Land used for motorcross at Stratford Road A422, Wroxton, Oxfordshire – a review of the great crested newt evidence

Project: Land used for motorcross, Stratford Road A422, Wroxton, Banbury, Oxon, OX15 6HX

Deliverable: Review of great crested newt evidence (case 21/00517/F)

Date: 11th July 2023

Figure 3: Location of target notes

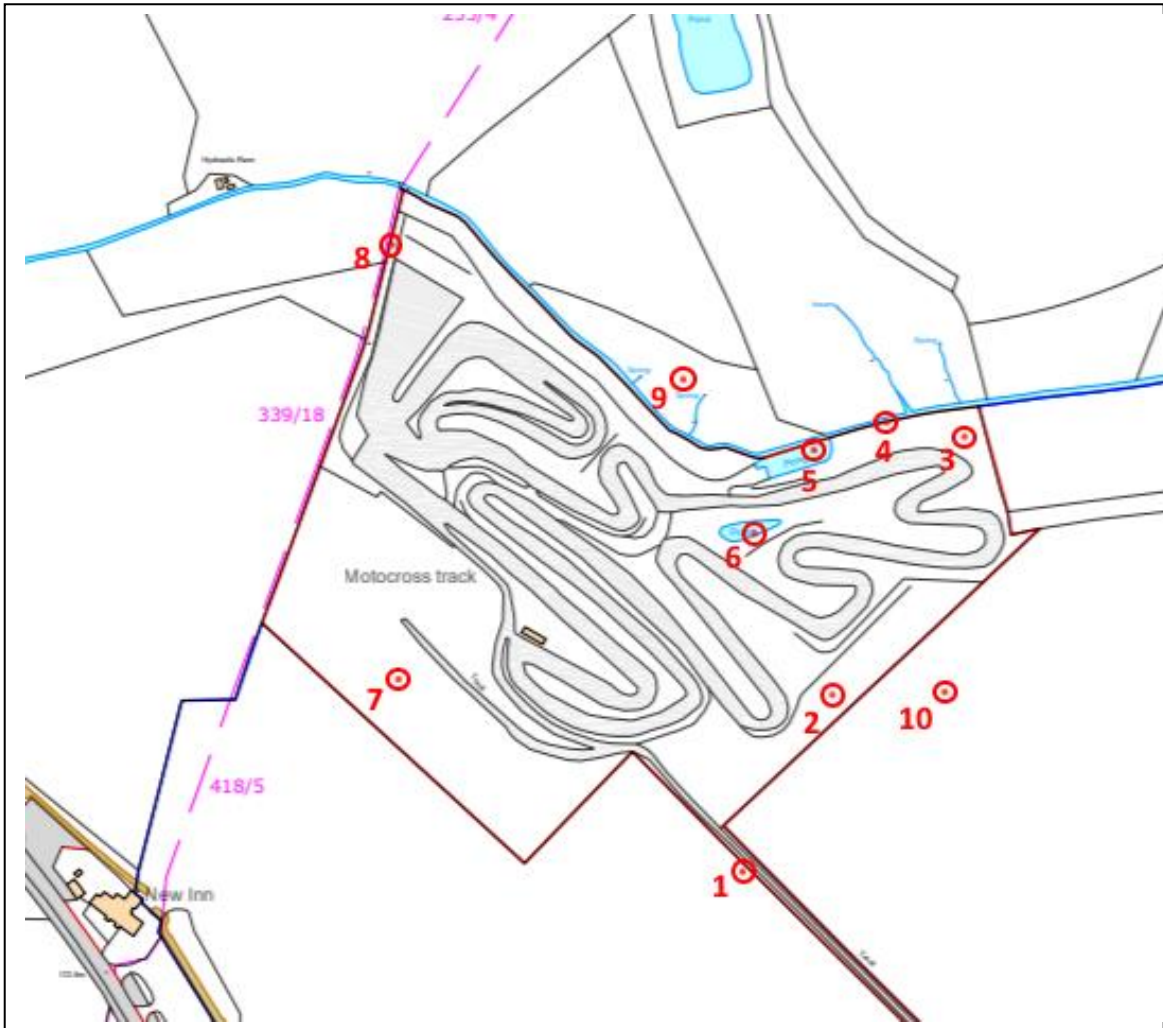
However, the more important point is that a full population survey of GCN in pond TN6 has not been conducted. Without knowing the GCN population size, the applicant's ecologist (CSA) is speculating that it is a small population. It could be a moderate or a large population. Furthermore, GCN population sizes vary greatly from year to year (both *de facto* and as measured by survey).

I believe that the proposed mitigation is too little for even a small population, and they have insufficient evidence to say what the population size is anyway. Once a full population survey has been conducted, it is likely that the size of challenge to mitigate the impacts will increase greatly. The achievability of the mitigation strategy must also be considered when making the planning decision.

In this case, the applicant would need to conduct a full GCN population survey (i.e. not a simple presence-absence survey by eDNA method). The population survey involves six nocturnal survey visits between mid-March to mid-June (not now possible until spring 2024) using at least three methods (usually torchlight, bottle-traps, and either egg-search or netting).
